HERTFORDSHIRE ECOLOGY

Application Engineering works comprising ground works and shaping of land to create a golf course (used only in conjunction with the Nyn Park Estate dwellinghouse) and erection of an associated single storey maintenance building

Address: Nyn Park, Well Road, Northaw, Potters Bar, EN6 4BS

Reference:6/2020/0311/MAJ

4.3 North Parkland Actions

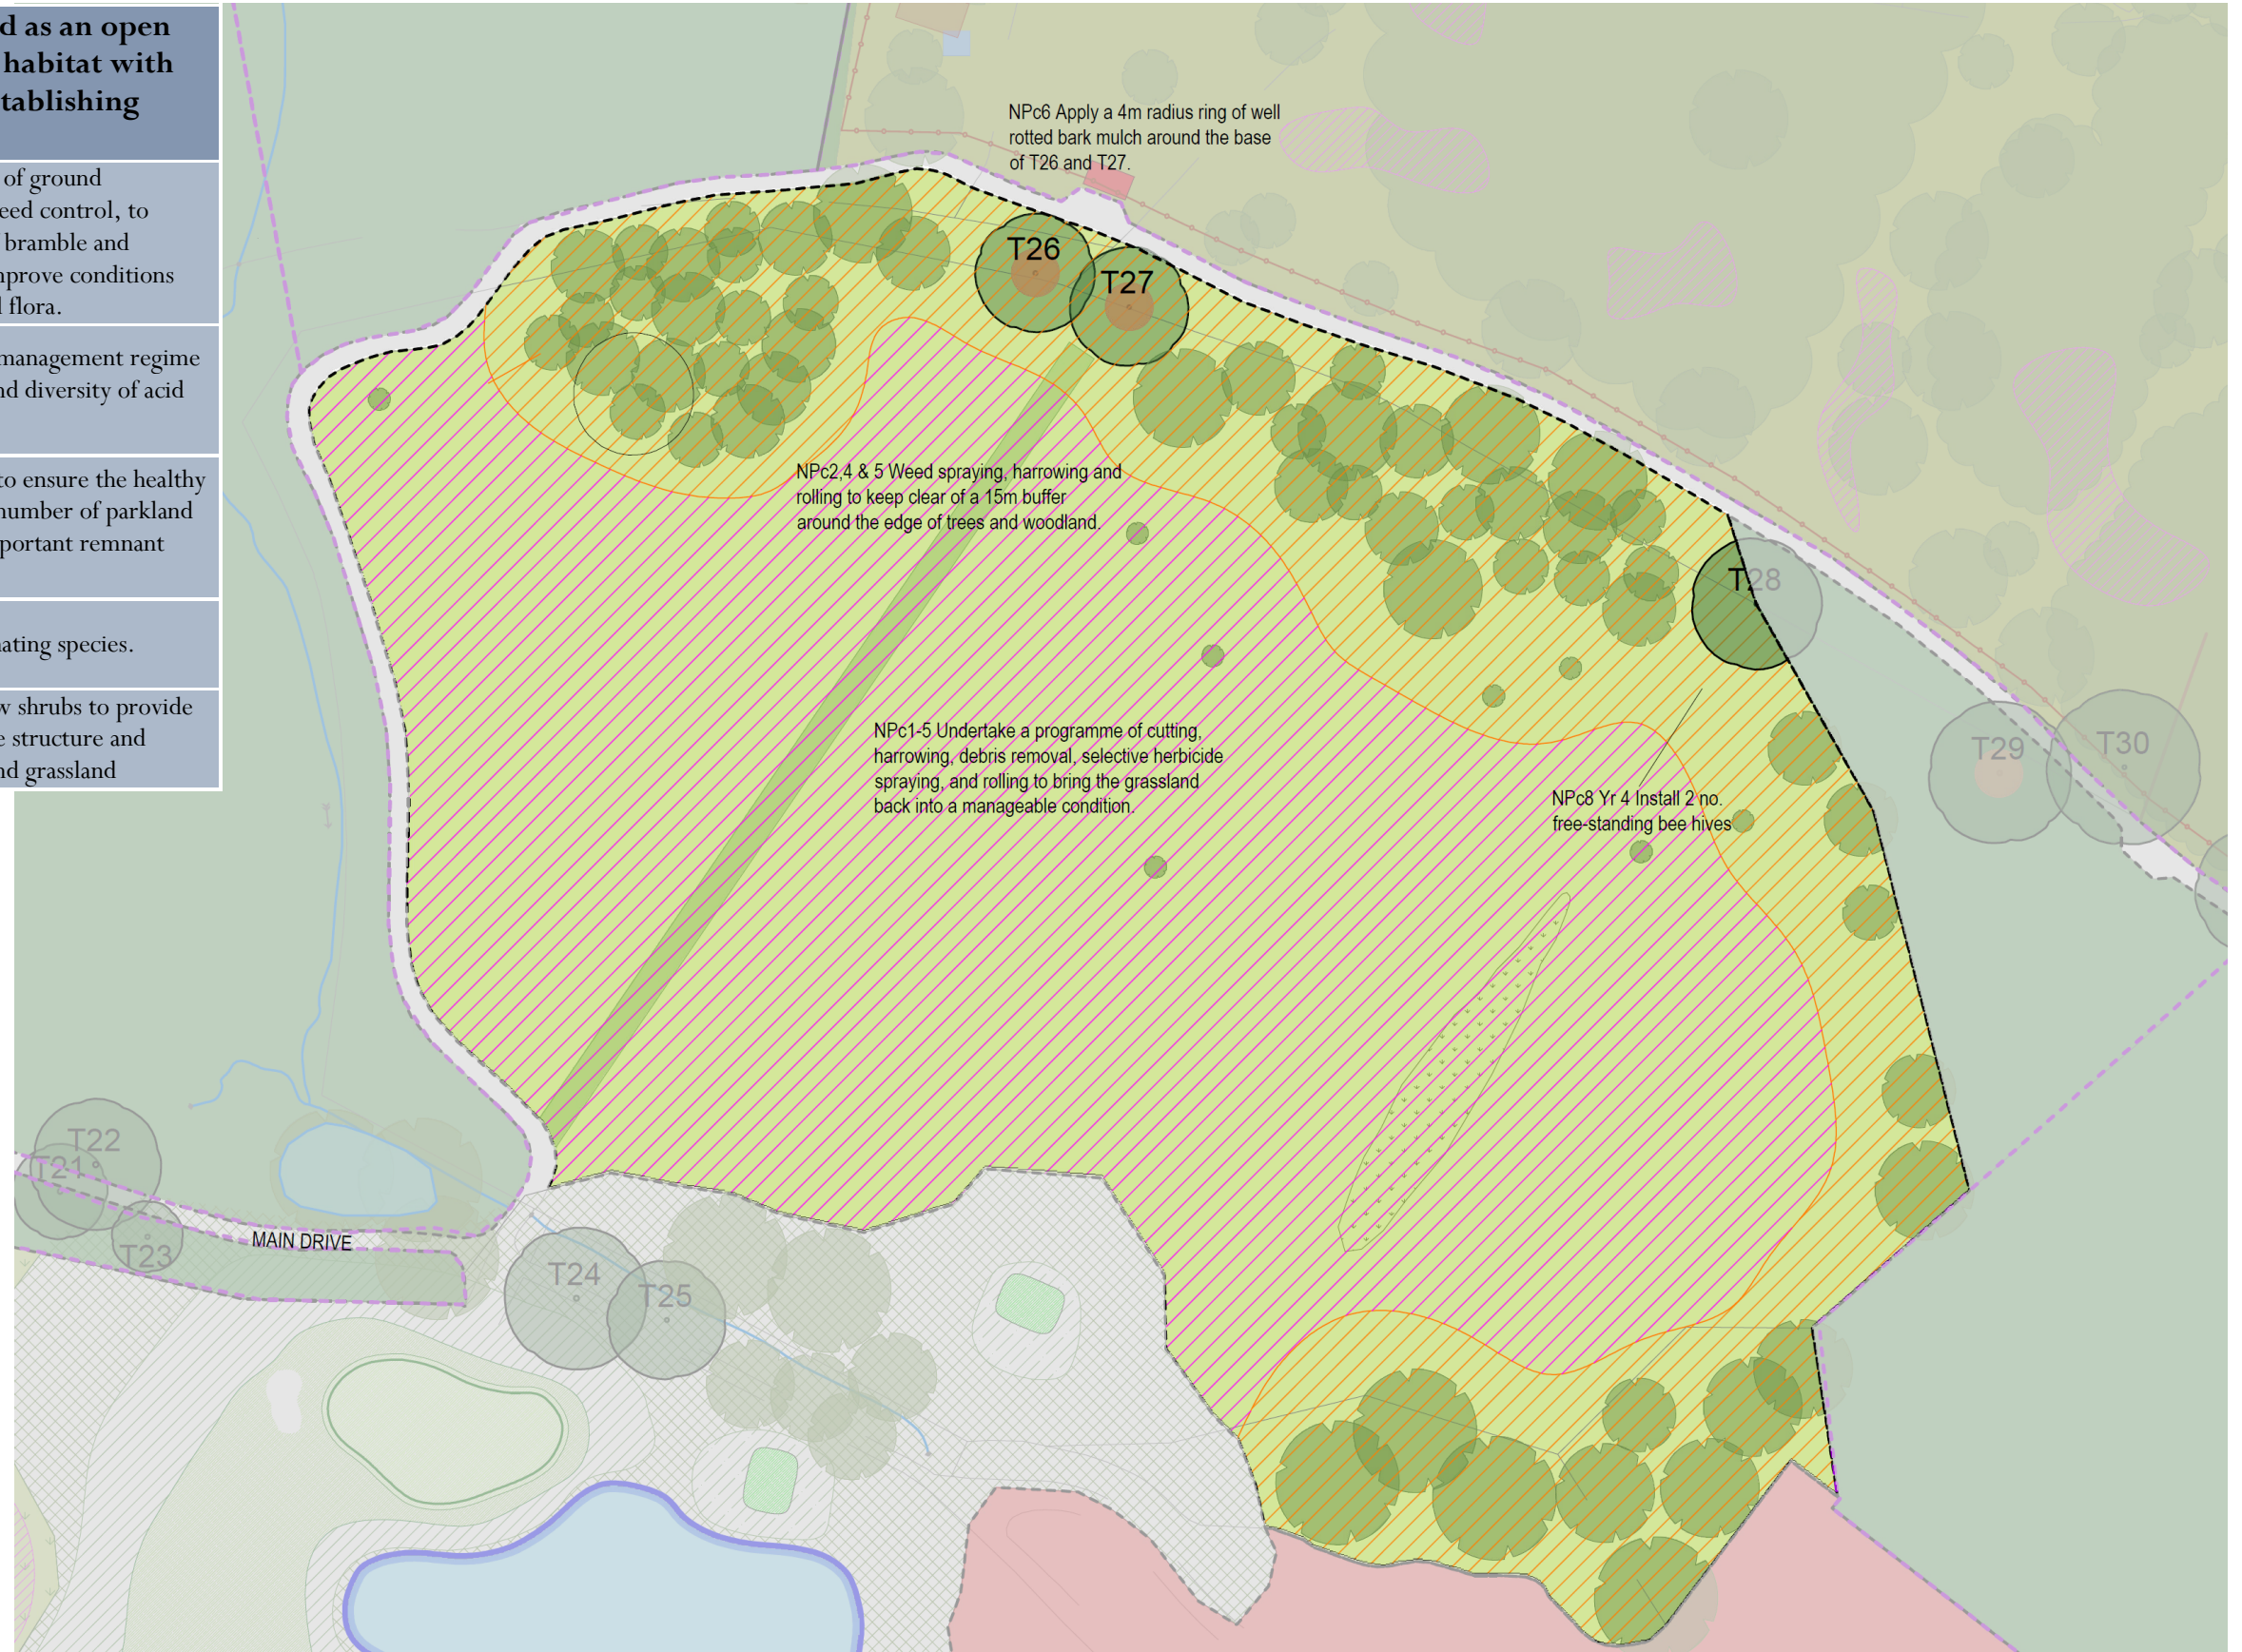
I note the intention not to graze the North Parkland area due to the owner's lack of enthusiasm for this. Given that:

- this area is identified as contributing towards biodiversity gain (Appendix A, Biodiversity Metric Gain Plan);
- grazing is proposed for the adjacent compartment;
- grazing represents the best and most practical means of helping to restore and maintain this habitat (although this doesn't have to mean continuous grazing);
- areas of originally proposed benefits of landscape restoration have been detrimentally affected by unauthorised golf course development;

this approach is unhelpful and disappointing.

The area is separated from the new house by a belt of trees so is not immediately adjacent to the residence, and historic maps in the management plan itself confirm this area was historically rough pasture - which means it was grazed by some form of livestock, the management invariably associated with almost all wood pasture / parkland.

There appear to be *no* plans to graze any of this parkland area; presumably the reference to grazing North Parkland on the other side of forest road by Agellus Projects Ltd in their note to WHDC of 15 March 2021 is to the heathland restoration area. However, I acknowledge that BNG is being achieved by other proposals at Nyn Park and that future monitoring and a review of the plan is proposed, against which its success can be judged and amended accordingly as necessary.

In relation to the ecological value of the North Parkland it **is** described as having species-rich grassland (section 3.2.2 of the Landscape Management Plan 2020-2030) with 7 or 8 Local Wildlife Site indicator species. Nevertheless, given it is presently dominated by coarse grasses, I accept the requirement for an initial limited selective use of herbicides as suggested to prevent the further decline of this grassland.
